An Bord Pleanála

Inspector's Report: To Director of Planning. Report prepared further to instruction received from DoP on 11th November 2014 following submission of draft application file for North South Interconnector Project of Common Interest (PCI) by Eirgrid to An Bord Pleanala PCI Unit on 7th November 2014 – Draft application file lodged in connection with potential S.I. application under s. 182A of the Planning and Development Act, 2000 (as amended)

PCI 0001 / 02.VC0054

Project promoter:	EirGrid PLC
Issue:	Project of Common Interest (PCI)/ Strategic Infrastructure (S.I.) application – Draft application file lodged in connection with potential S.I. application under s. 182A of the Planning and Development Act, 2000 (as amended) for that section of the North South 400kV Interconnector project falling within the Irish State
Nature of Development:	Proposed 400kV North South electricity interconnector from Woodlands substation Co Meath to State border.
Inspector:	Philip Green

Figure 2.1: Transmission Systems in Ireland and Northern Ireland (2015)

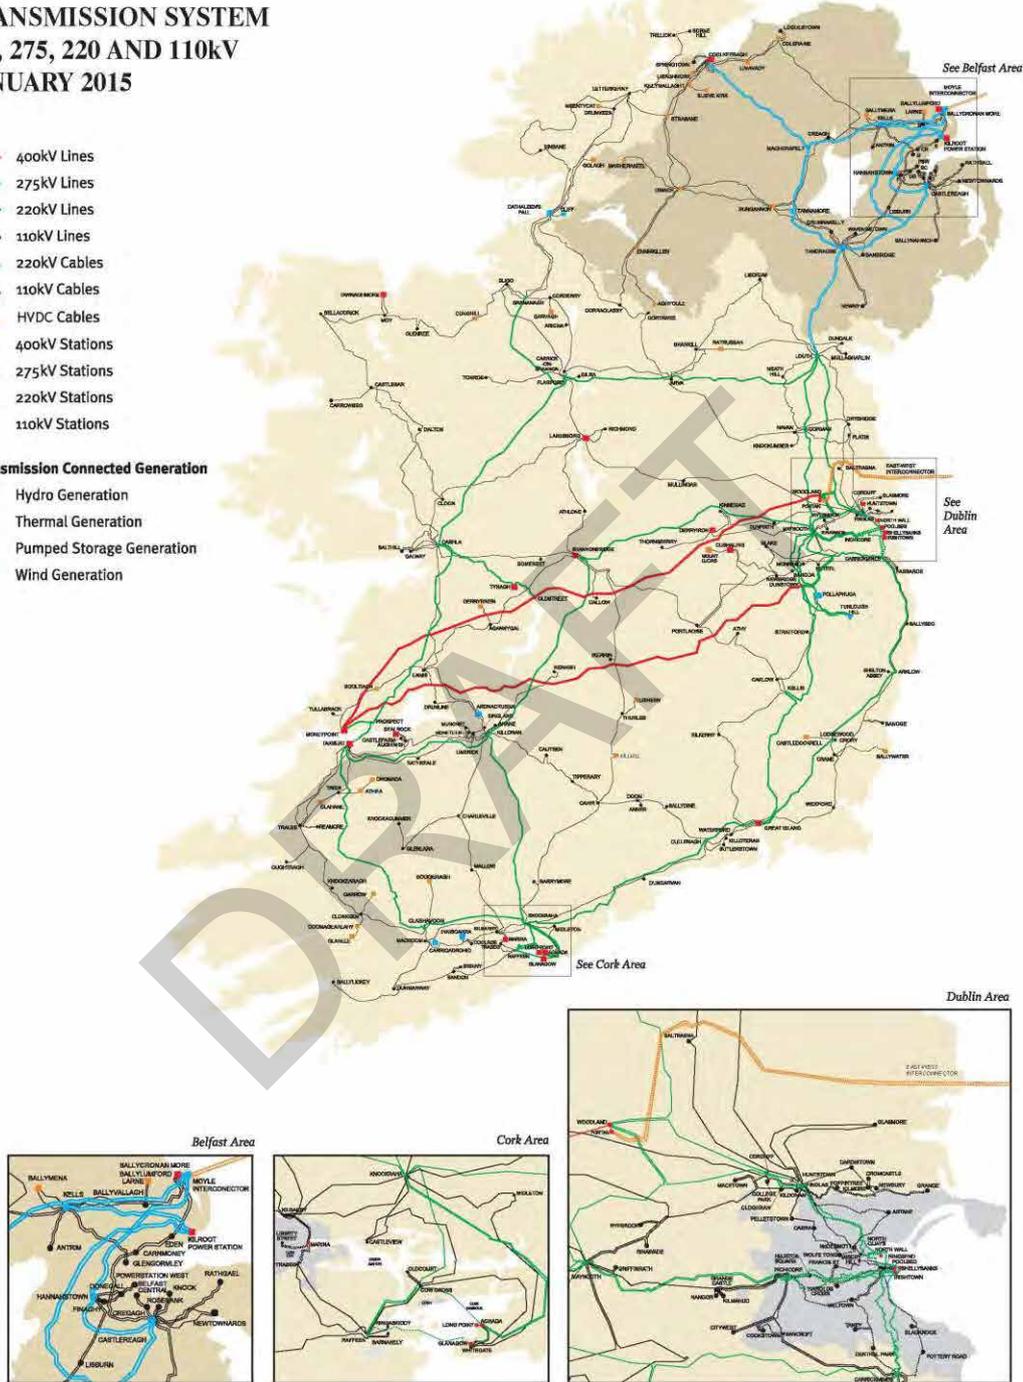
- The EIS should ensure that all figures and illustrations contained in Volumes 3A – 3D are fully legible. This relates in particular to the following
Figure 2.1 on Page 2-4 of Volume 3B.
Figure 6.1 Page 6-3 of Volume 3B.
Figure 7.10 on page 7-22.
Figure 4.1 on Page 4-19 of Volume 3B.

Figure 13.1: Indicative Corridors of the Proposed Leinster Orbital Route

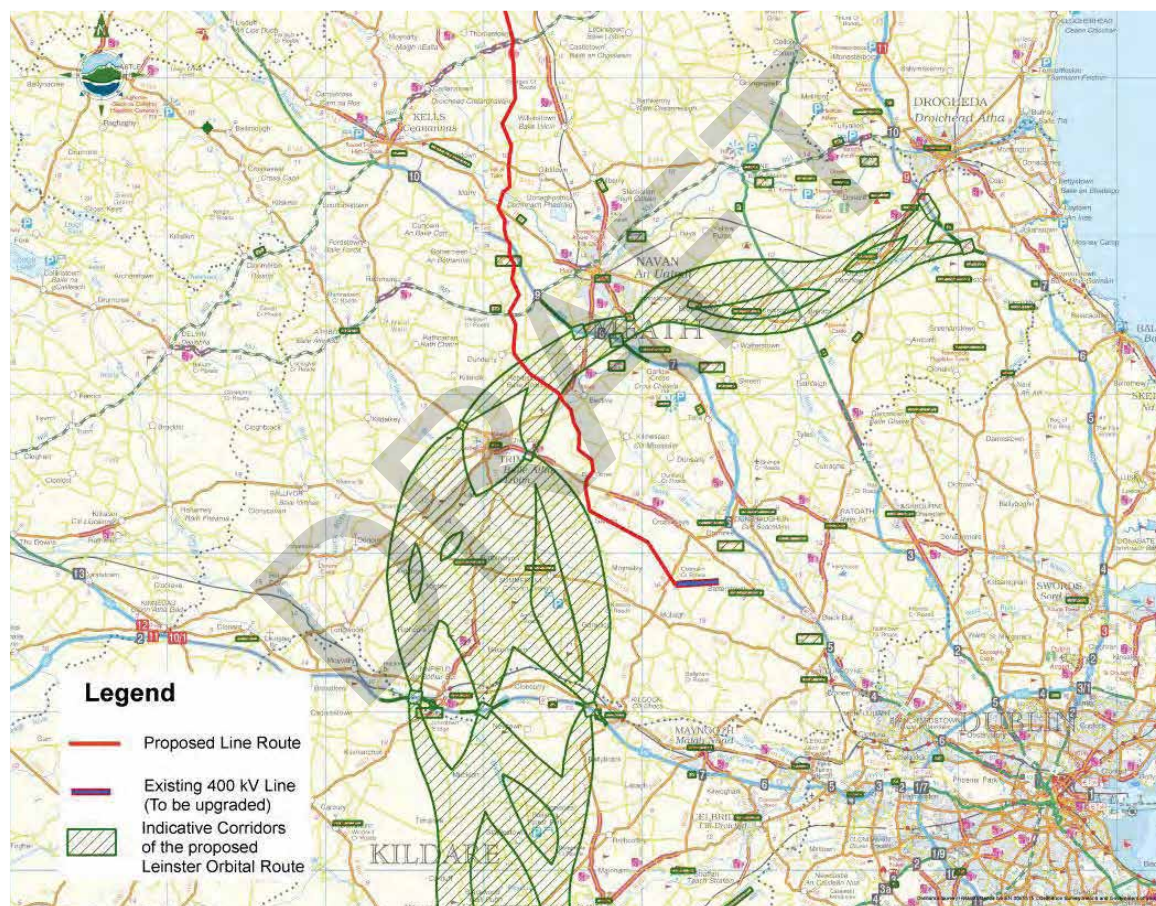
- 2.5.7 Material Assets:
The indicative route of the proposed Leinster Orbital Route and relationship with the proposed development should be identified, based on best available information.
Confirm where, if any, re-routing of existing overhead lines will be required.
A preliminary construction traffic management plan should be submitted outlining how these matters will be addressed. In this respect Eirgrid's attention is brought to the pre application consultation discussions held in connection with file 02. VC0054 on the 23rd December 2014
